Ecology response

**From:** Jonathan Best <Jonathan.Best@arun.gov.uk>  
**Sent:** 22 January 2025 09:35  
**To:** Planning.Responses <Planning.Responses@arun.gov.uk>  
**Cc:** Amber Willard <Amber.Willard@arun.gov.uk>  
**Subject:** WA/108/24/PL

Stoneybrook Farm Eastergate Lane Walberton BN18 0BA,

<p>Photograph 7: B1: Potential bat roost location</p>	<p>Photograph 8: B1: potential bat access under weatherboarding</p>

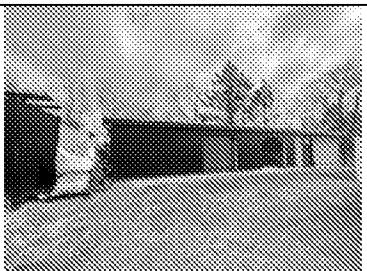
The bat survey is fine. A bat roost was found in building B1. A bat licence is required for works to building B1.

*Alterations to the internal layout of B1 has the potential to result in the destruction and/or disturbance to low numbers of individual Pipistrelle species of bats. Due to the presence of two bat droppings recorded upon an internal wall within a stairwell within B1, it is considered likely attributed to an individual opportunistic Common or Soprano pipistrelle bat as an occasional day roost. B1 has been assessed and is considered to be a low significance day roost, used by a low number (<3), or an individual pipistrelle species of bat, and the roost is likely to be value at a Site Level of importance.*
